7. The Ridings,
Milton Keynes.

ARUN DISTRICT COUNCIL

This is regarding the property development at 9. The Ridings Bulb ATN.

Elevations 1:100

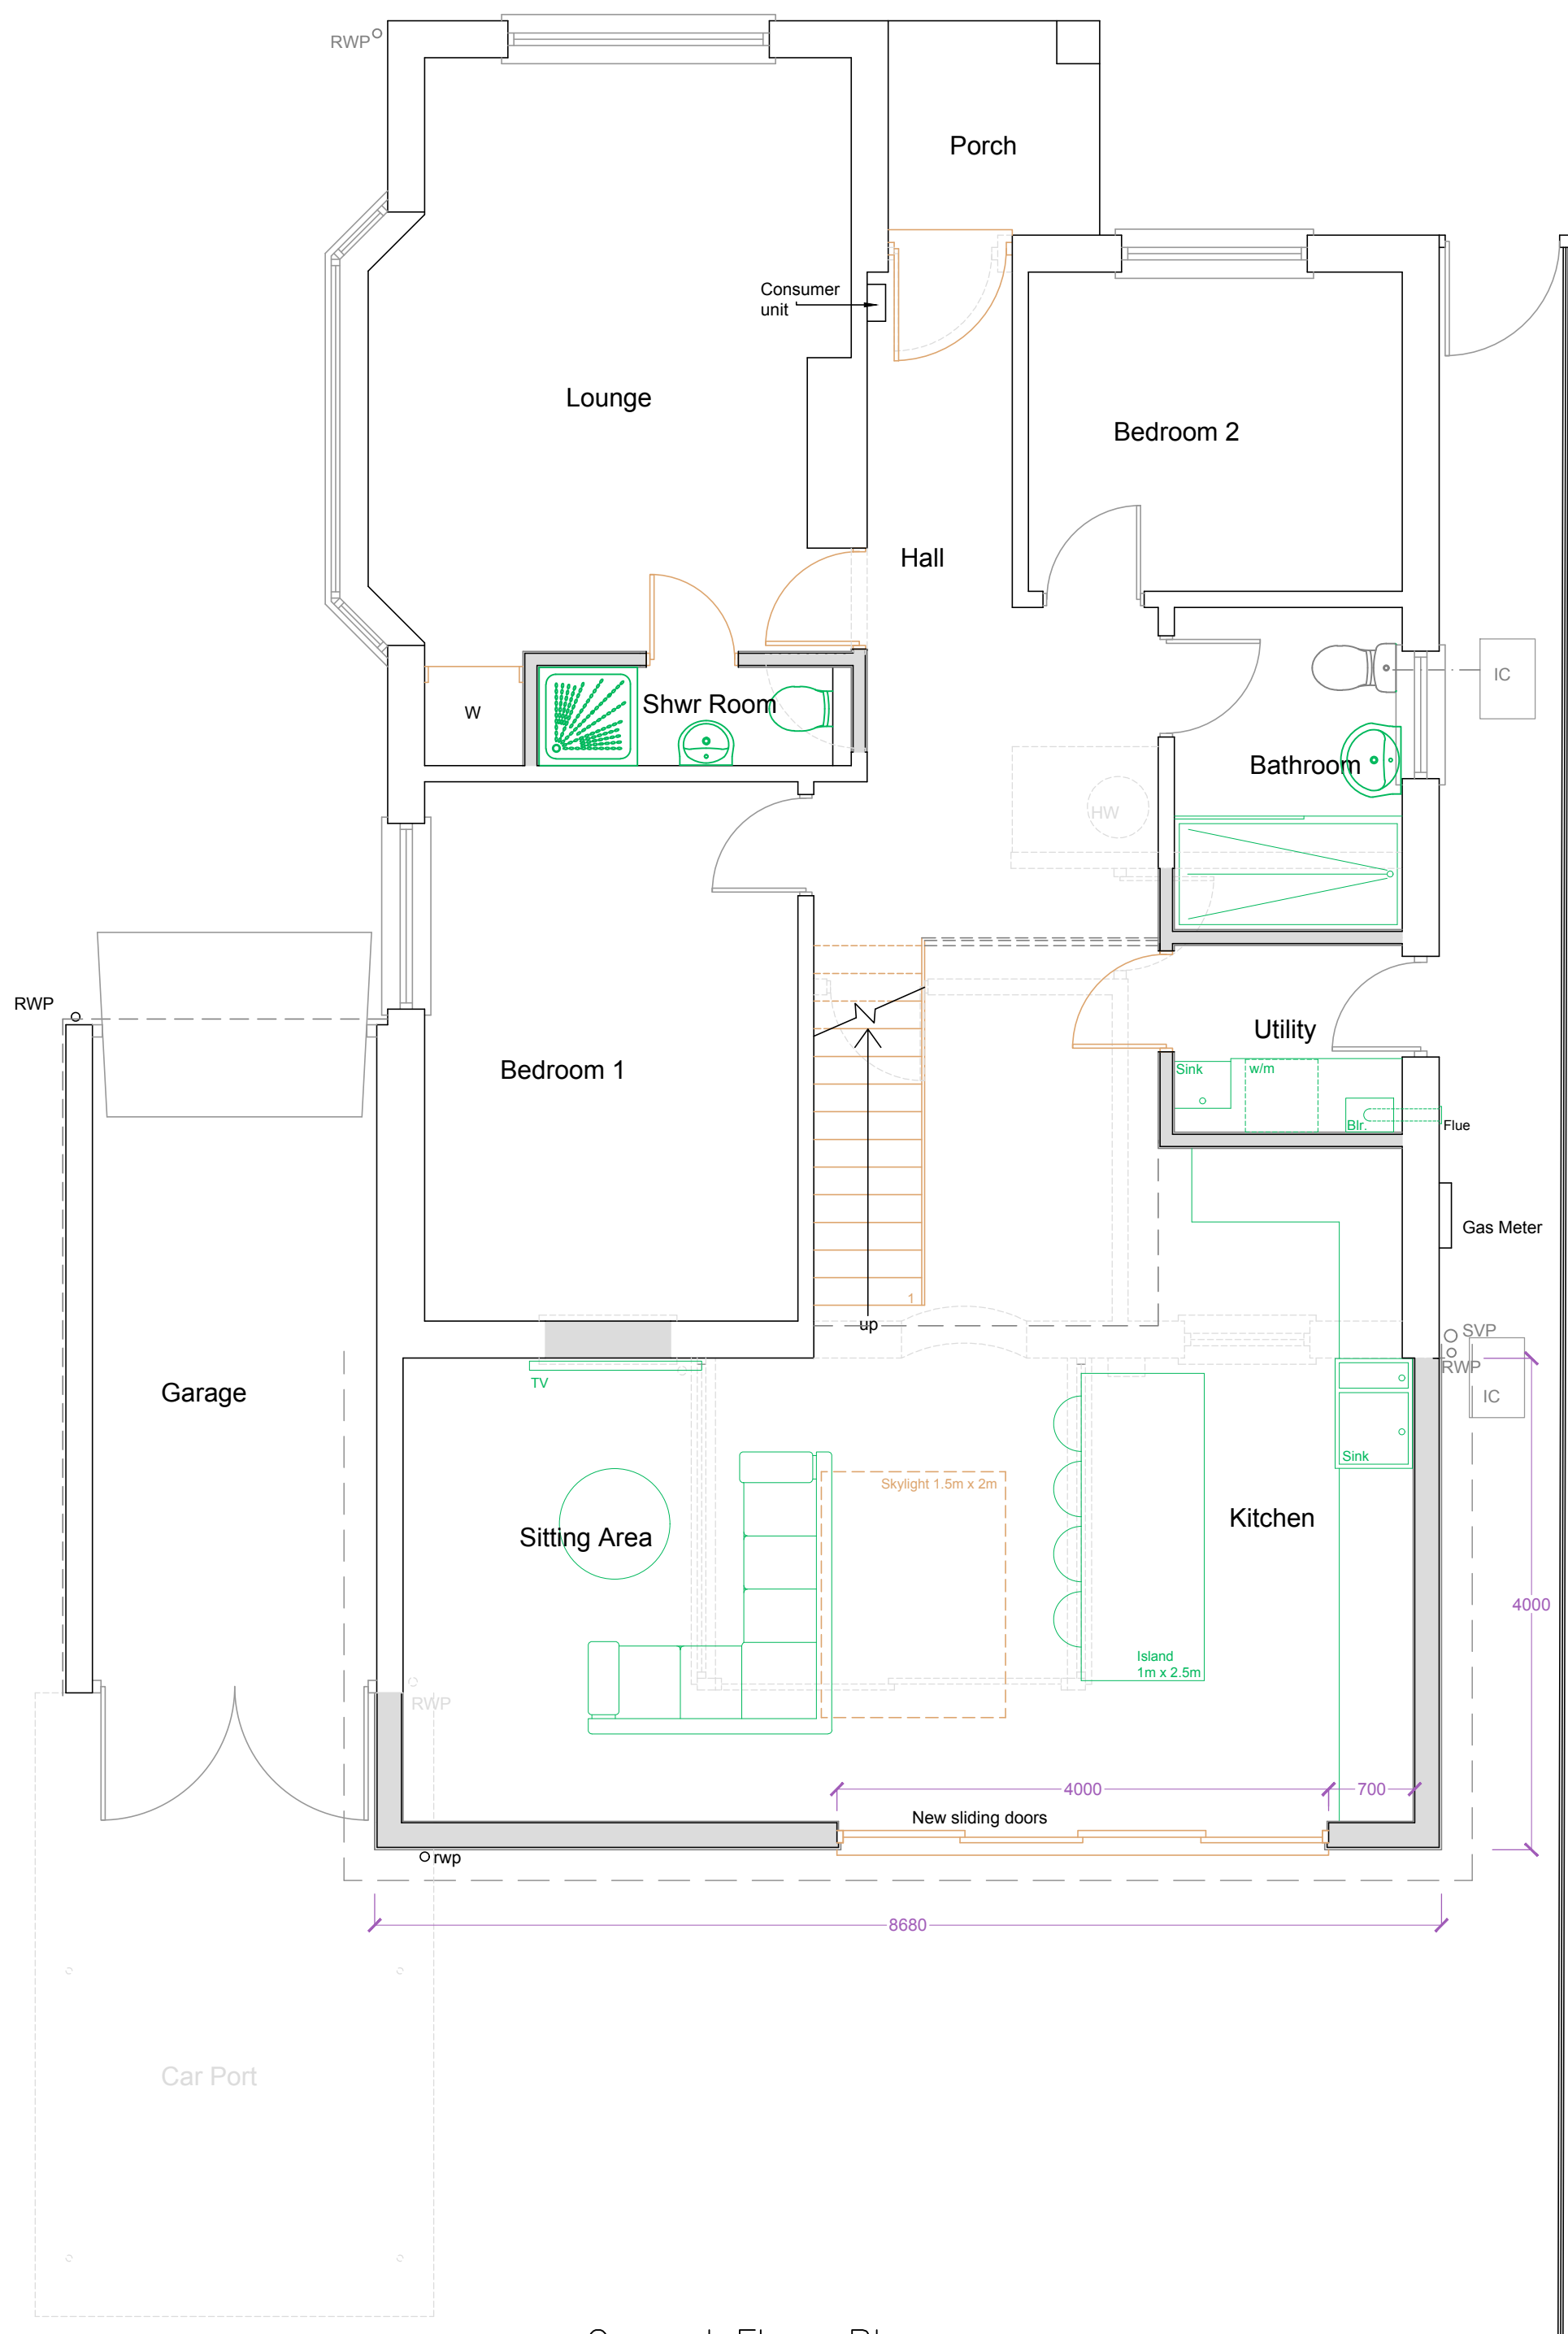
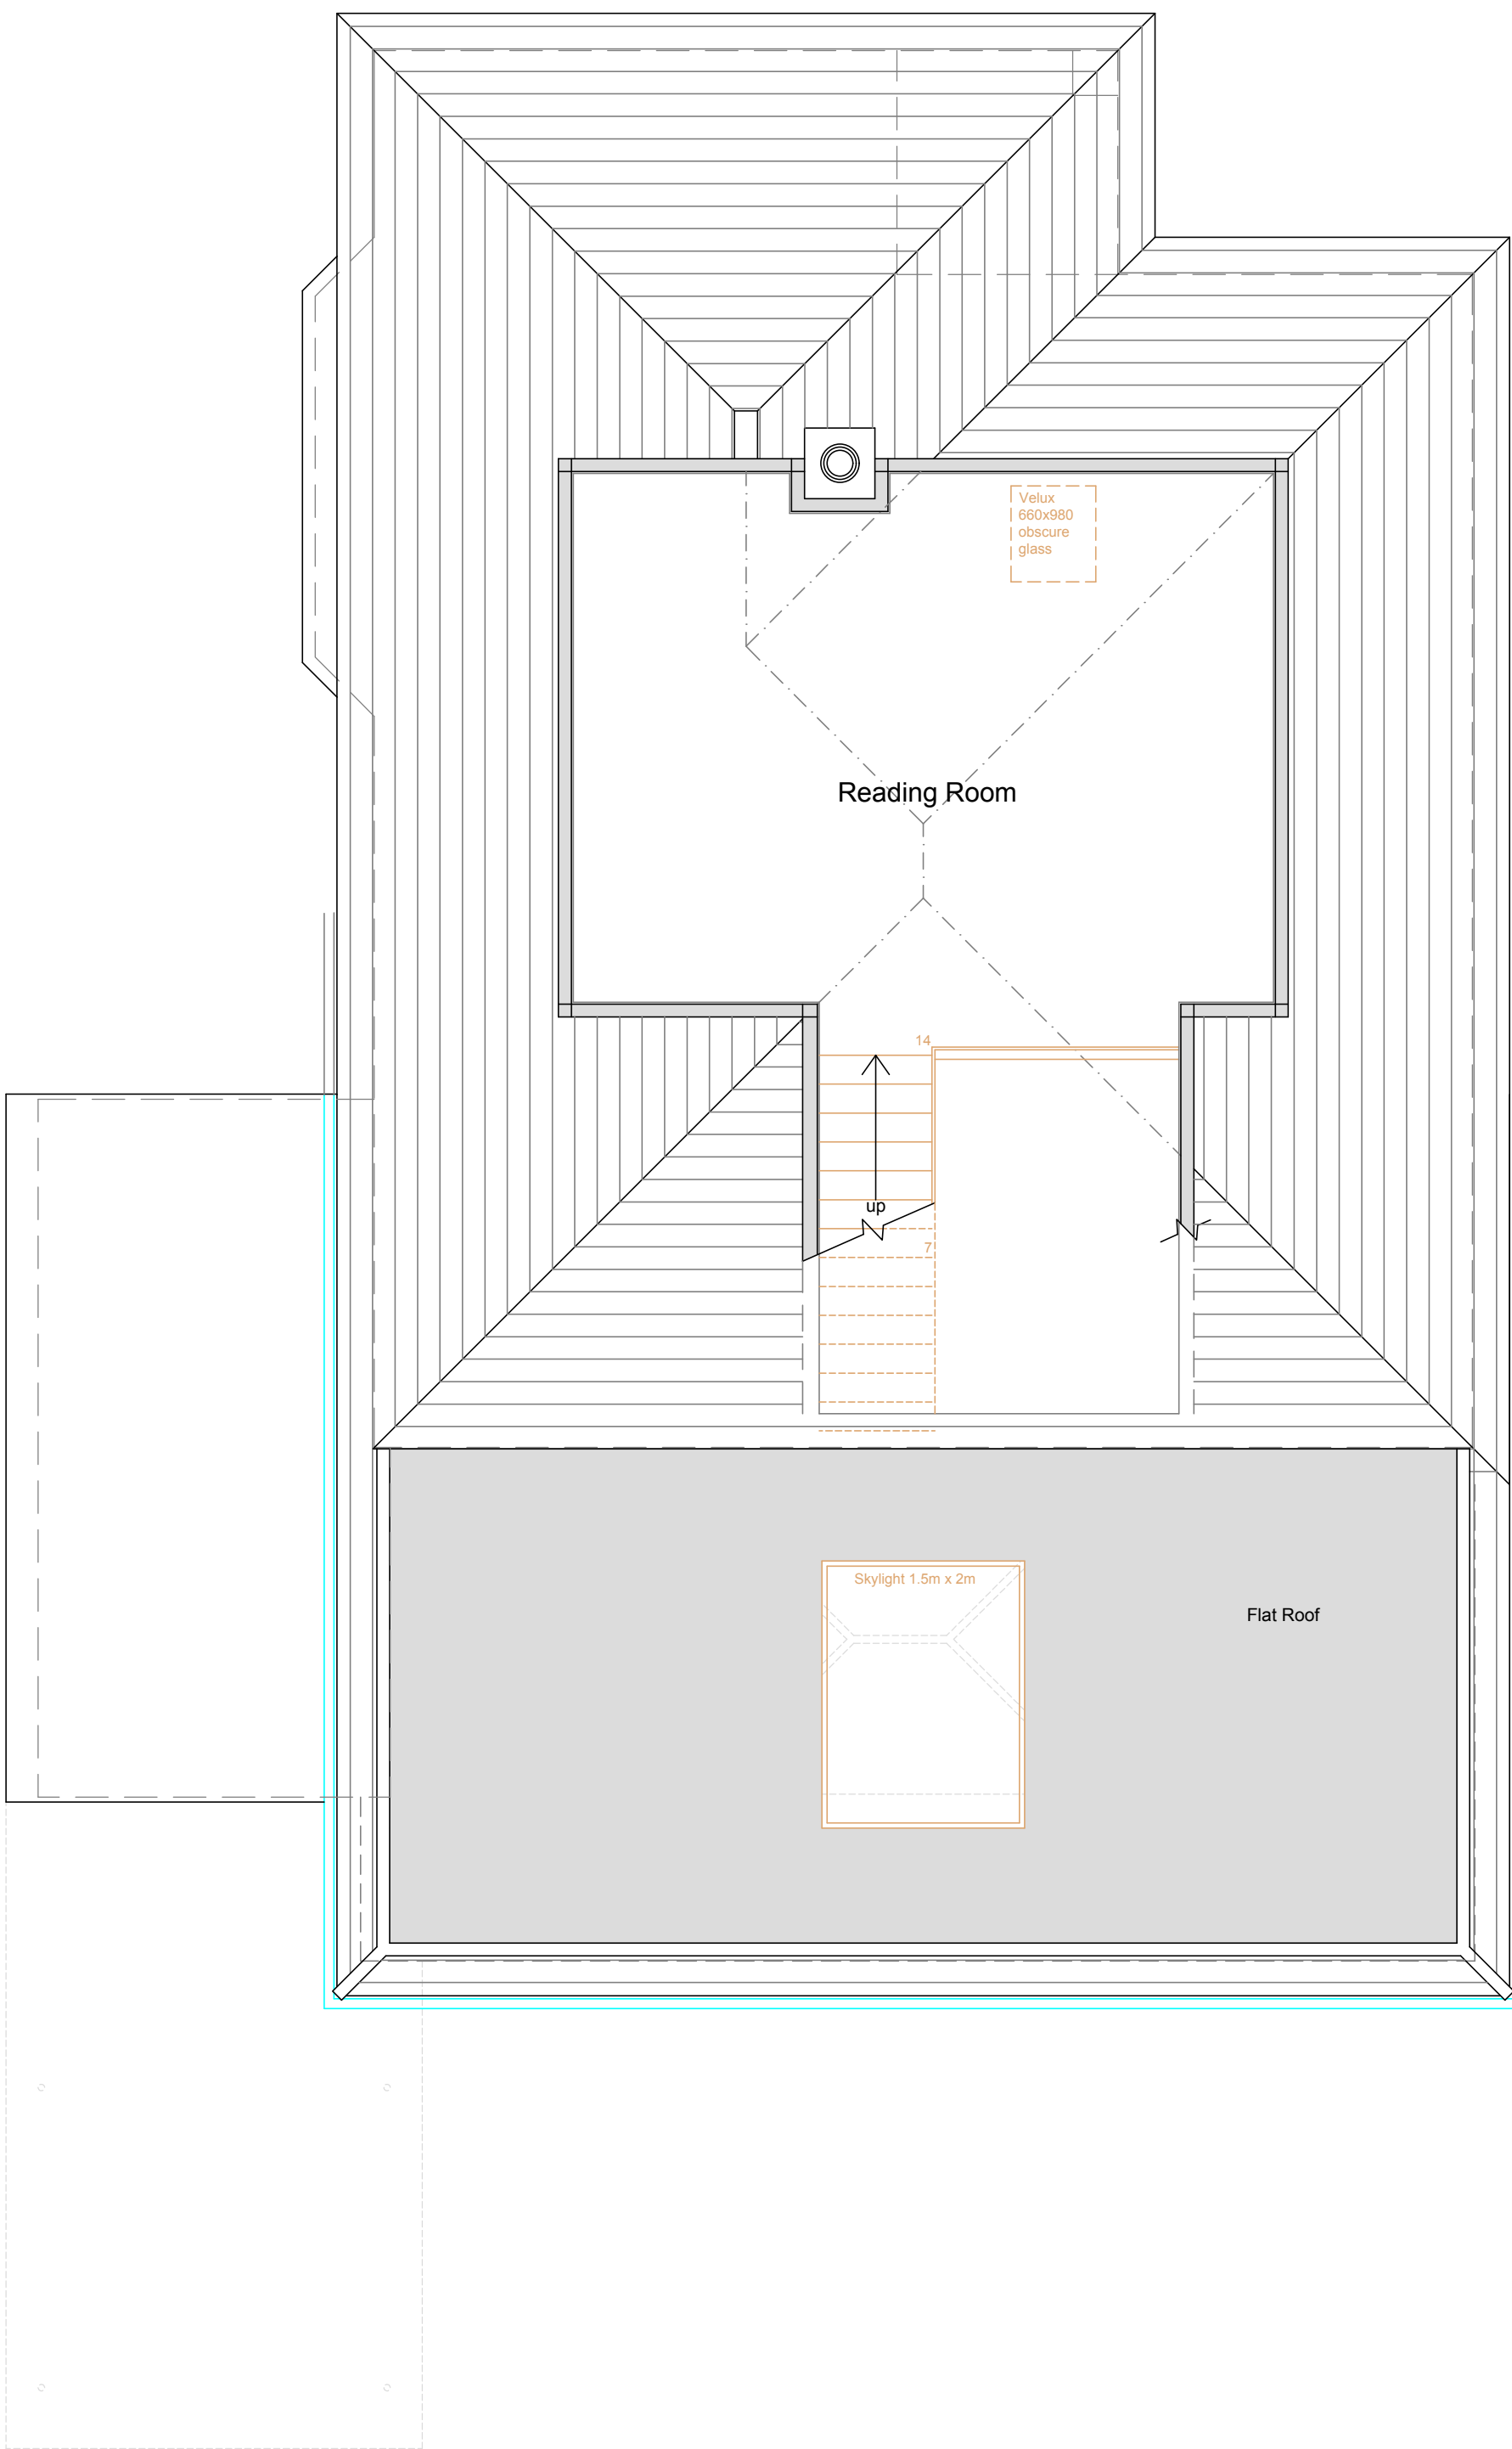
I can confirm that the extension to the property was already under construction by 8th October. It already stands 9' 4" at its lowest point, this is before roofing material and light-well have been fitted. and despite subsequent plans being submitted for completion height 8' 2"!

The unauthorized extra height of this extension, which is a mere 3' 3" from my boundary is having a marked negative impact to the privacy to my bungalow, garden & light to my conservatory.
